Your reference: 07\_0161 MOD 2  
Our reference: EF13/3853, DOC14/212948-01  
Contact: Dr. Sandie Jones/Claire Hindle (02) 62297002

**EPA Response – Submissions response Modification Request for Dongwha Timbers, 1 Sandy Lane Bombala (07\_0161 MOD 2)**

**Attachment 1:**  
**Recommended General Terms of Approval – Dongwha Sawmill Bombala**

**Attachment 2:*****Revised recommended licence conditions – Dongwha modified plant upgrade***

Figure 2.1

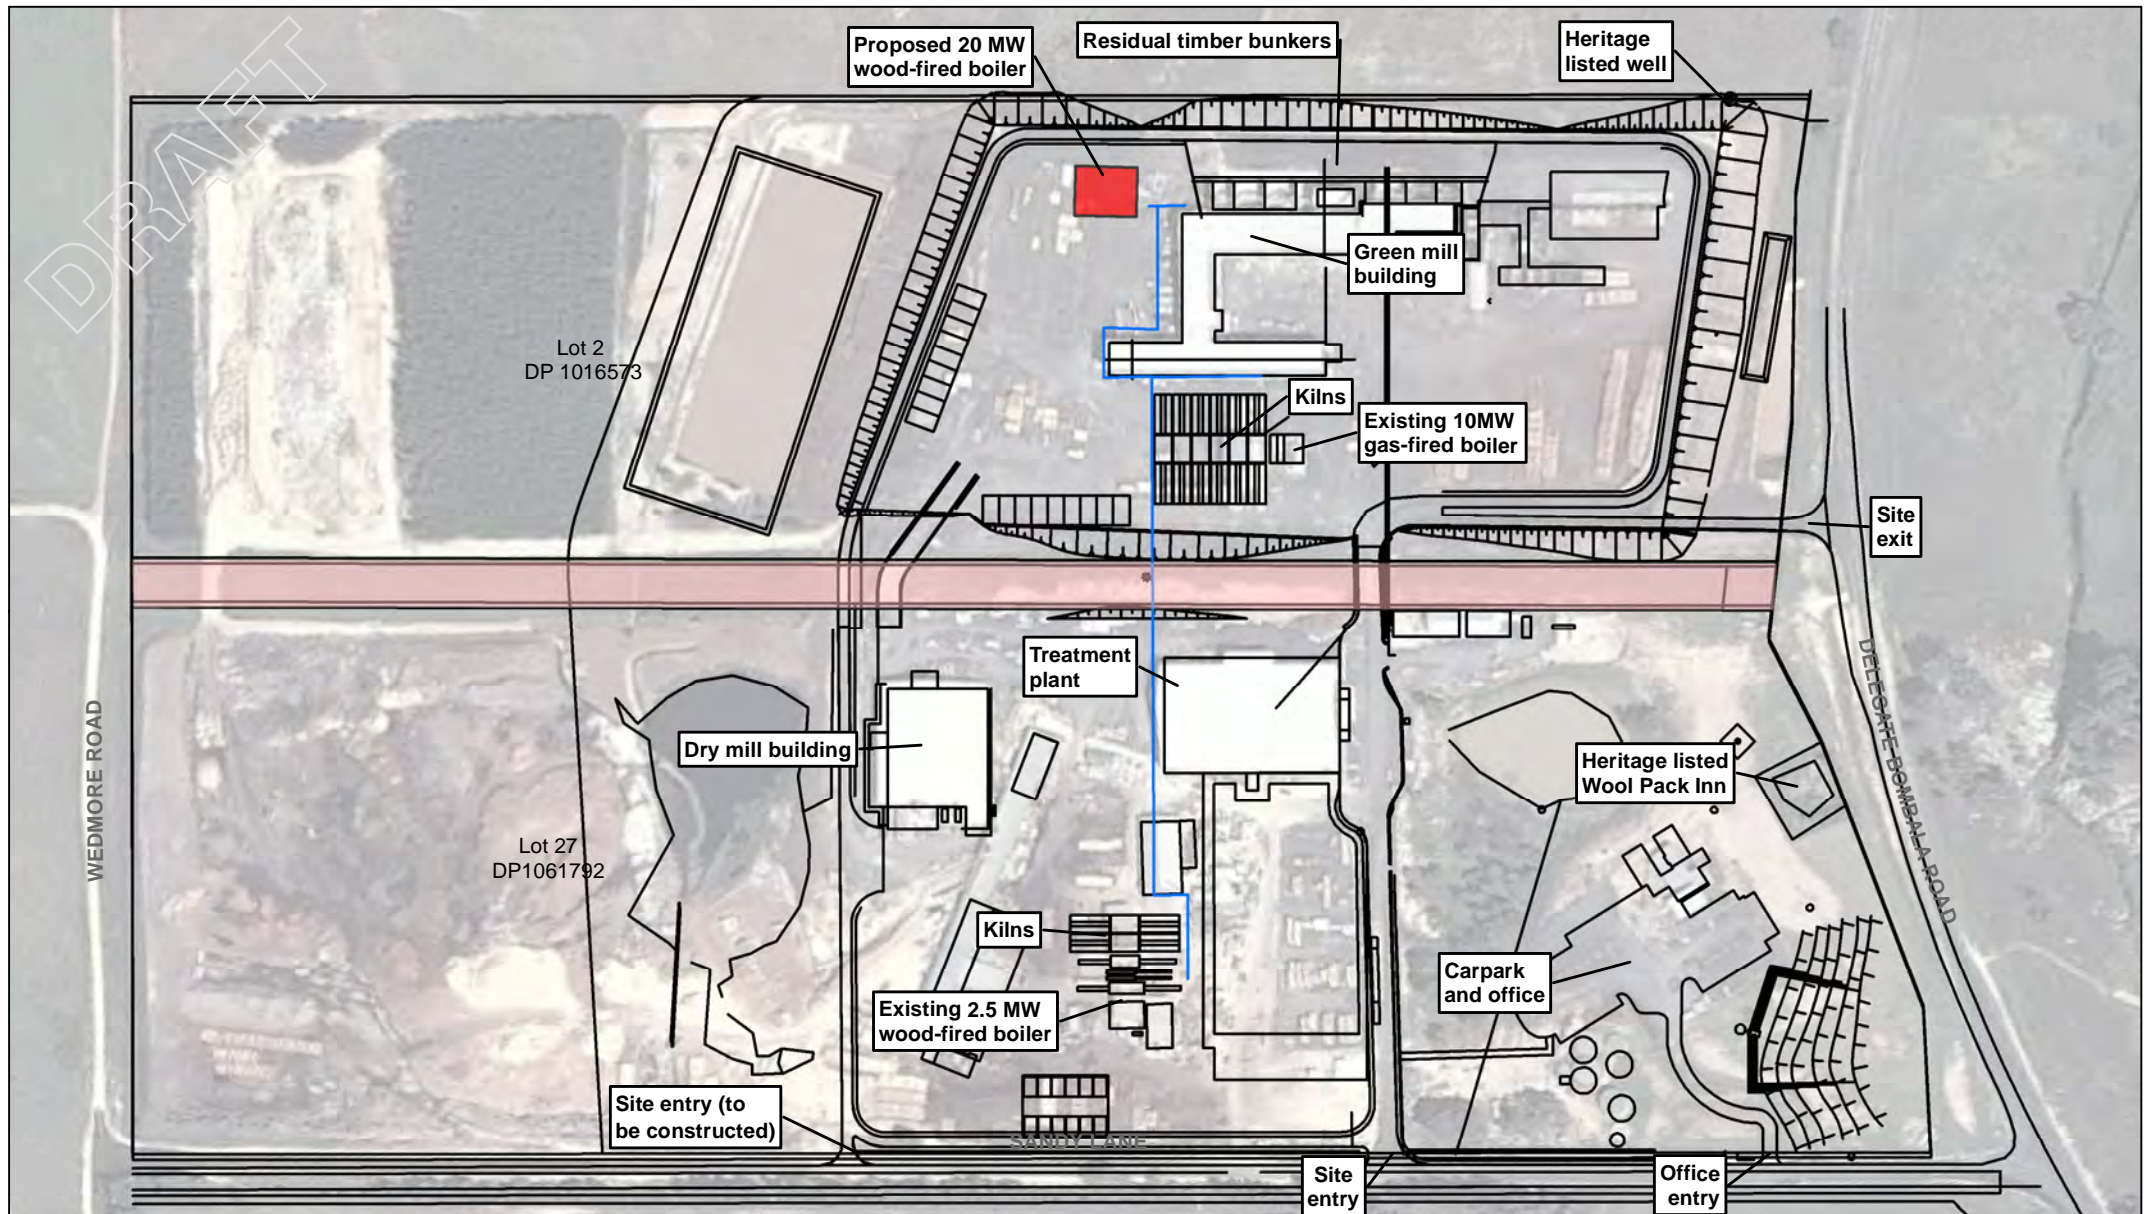
If DP&E approve the modification to the plant upgrade, modify licence to refer to a new emission point DP5 and delete emission points 23 and 24 **following decommissioning**. Emission point to be included at P1.1 (next number is 35). Add emission point DP5 to figure D10, locating it as shown in figure 2.1 of the EIS dated 22<sup>nd</sup> August 2014.

35	Discharge to Air	Discharge to Air	Exhaust stack from wood-fired boiler marked "DP5" on figure D10 of the Environmental Assessment dated 22 <sup>nd</sup> August 2014
----	------------------	------------------	--
